**REQUEST**

Current Zoning: MX-1 INNOV (mixed-use residential, innovative)  
Proposed Zoning: MX-2 INNOV with 5-years vested rights (mixed-use residential, innovative)

Approximately 124.60 acres located along the east side of Tom Short Road, west of Red Rust Lane, and north of Ardrey Kell Road.

Staff recommends approval of this petition upon resolution of outstanding issues related to transportation and land use.

- Traffic Signal
- Stop Sign Control
- Proposed Signal
- Existing Laneage
- STIP I-6030
- Phase 1 Suggested Laneage
- Phase 2 Suggested Laneage
- Phase 3 Suggested Laneage

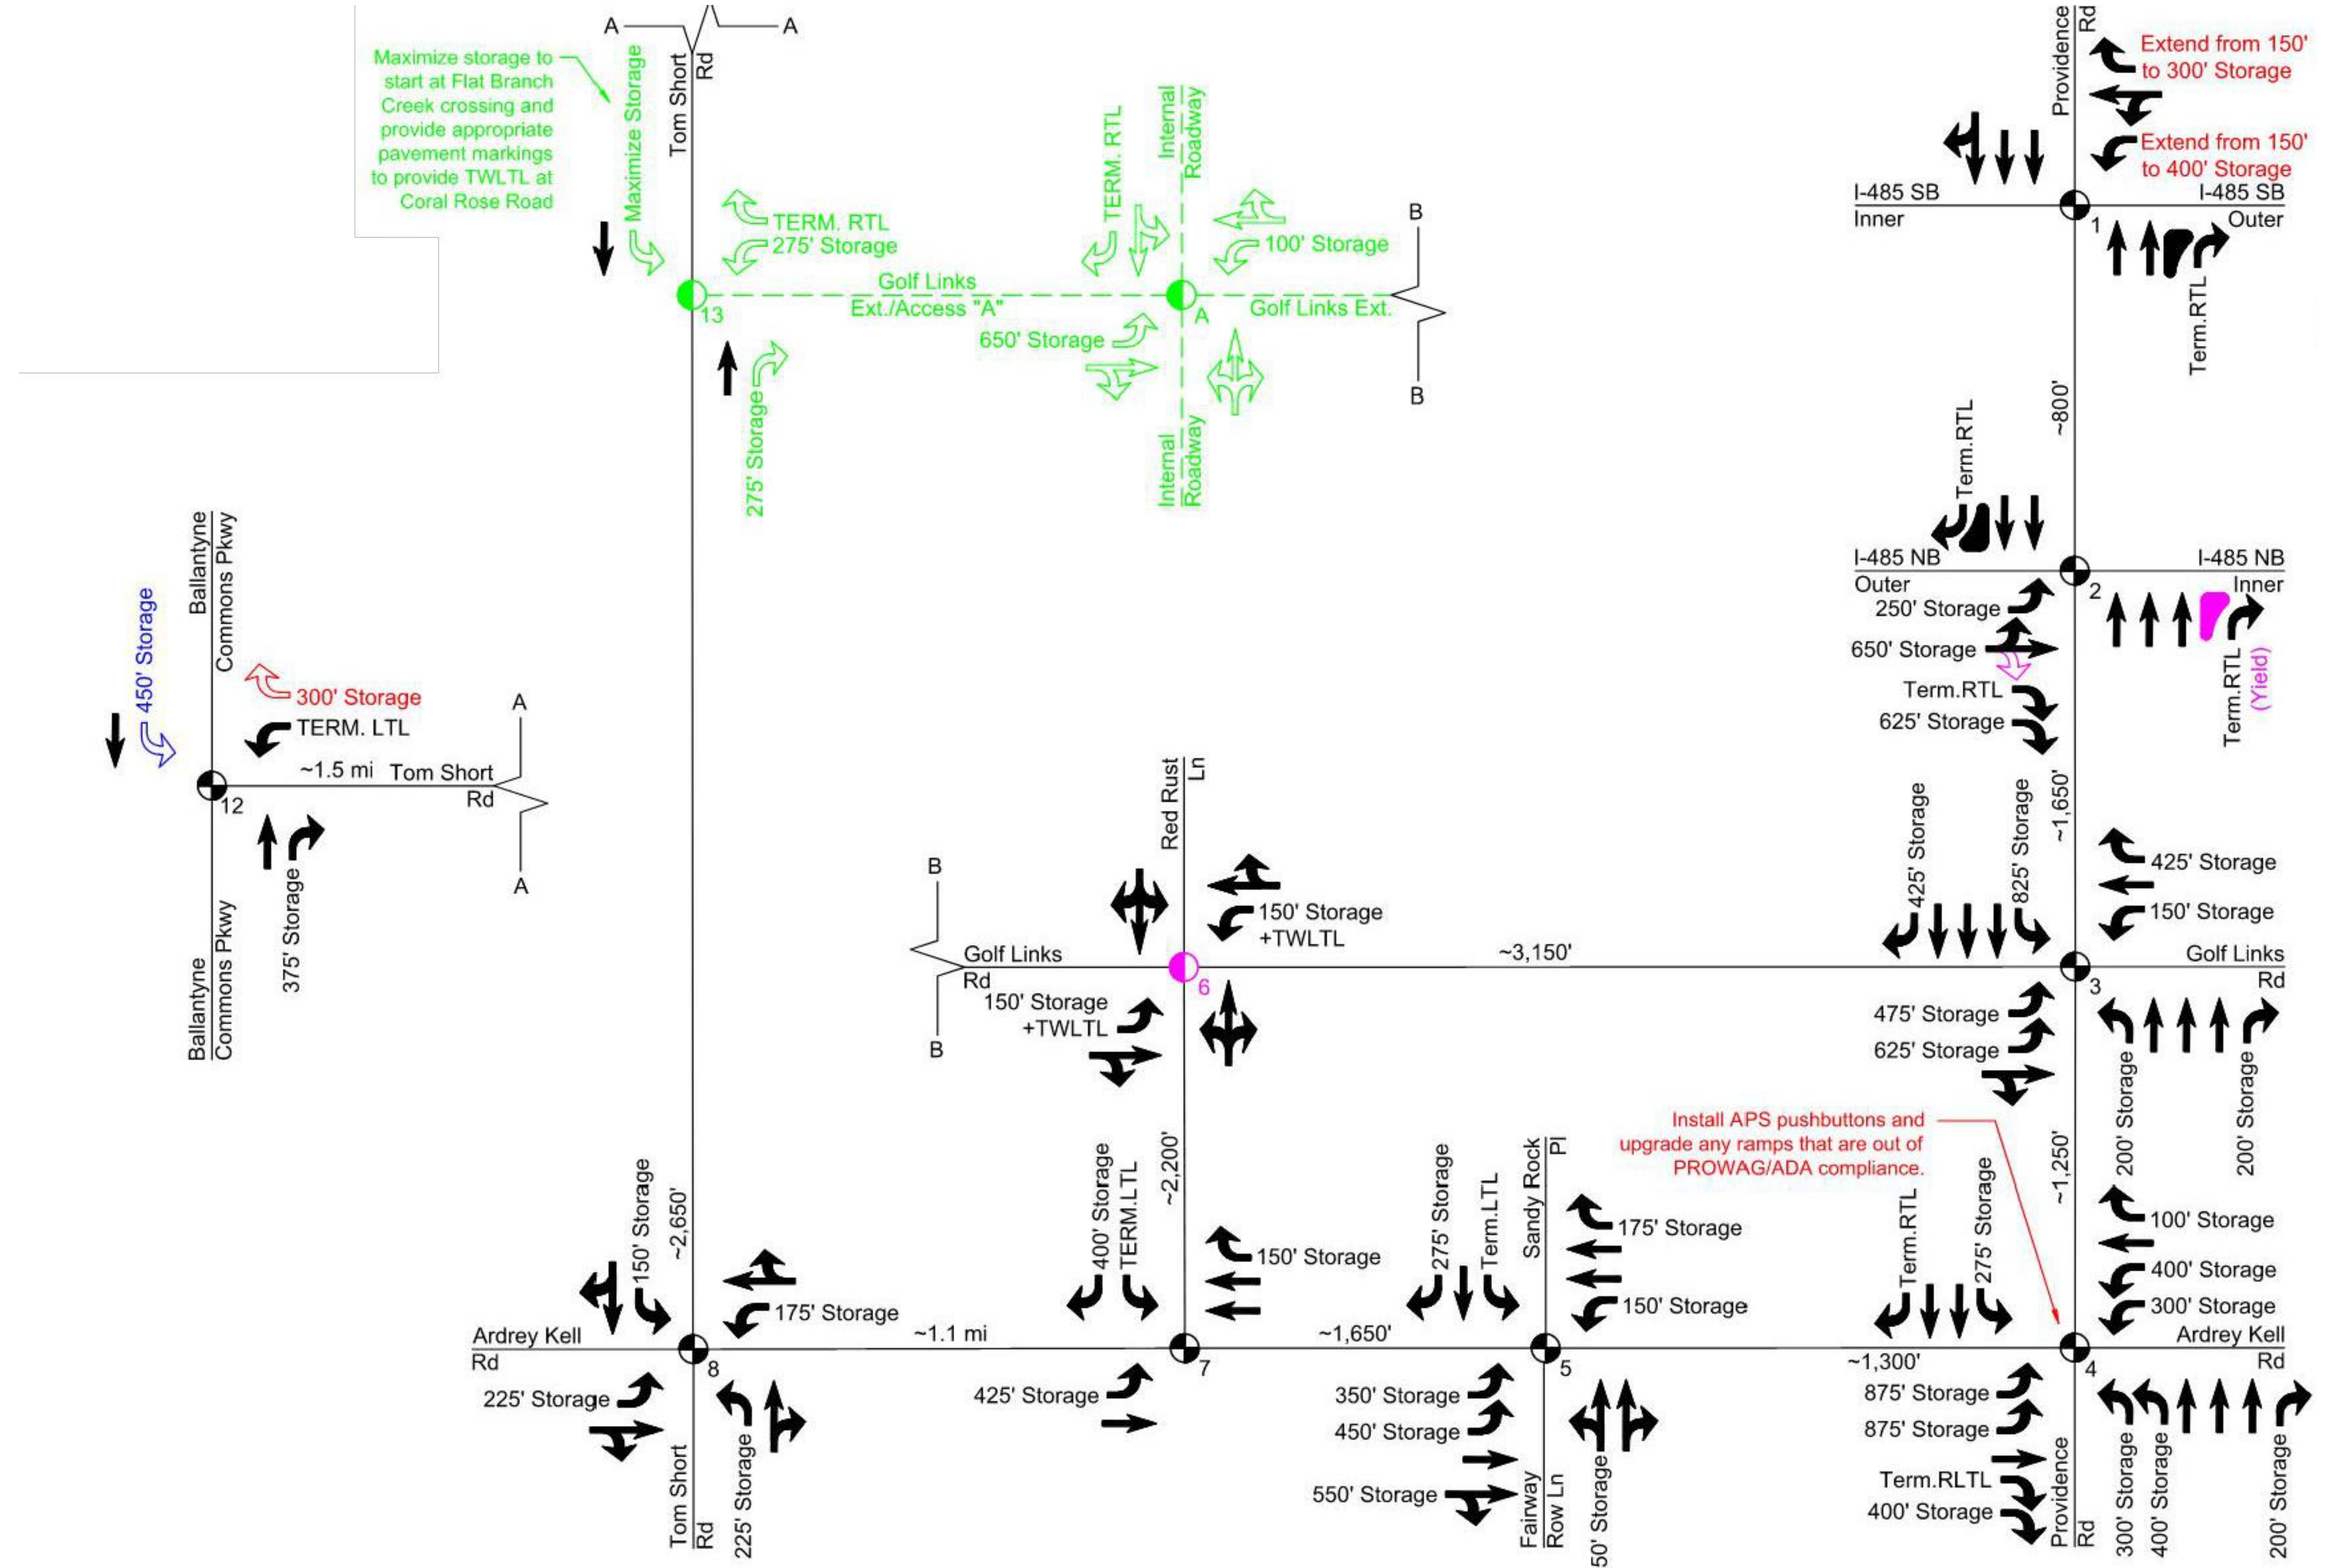
1. Revise transportation improvements notes for I-485 Southbound Ramp & Providence Road and Tom Short Road & Polo Ridge Elementary School Driveway-Out as specified by CDOT.
2. Revise the wording in the conditional notes for the internal intersection "A" to match the TIS as specified by CDOT.
3. Revise the transportation improvements for the second access on Tom Short Road as specified by NCDOT and update the TIS accordingly or remove the second access.
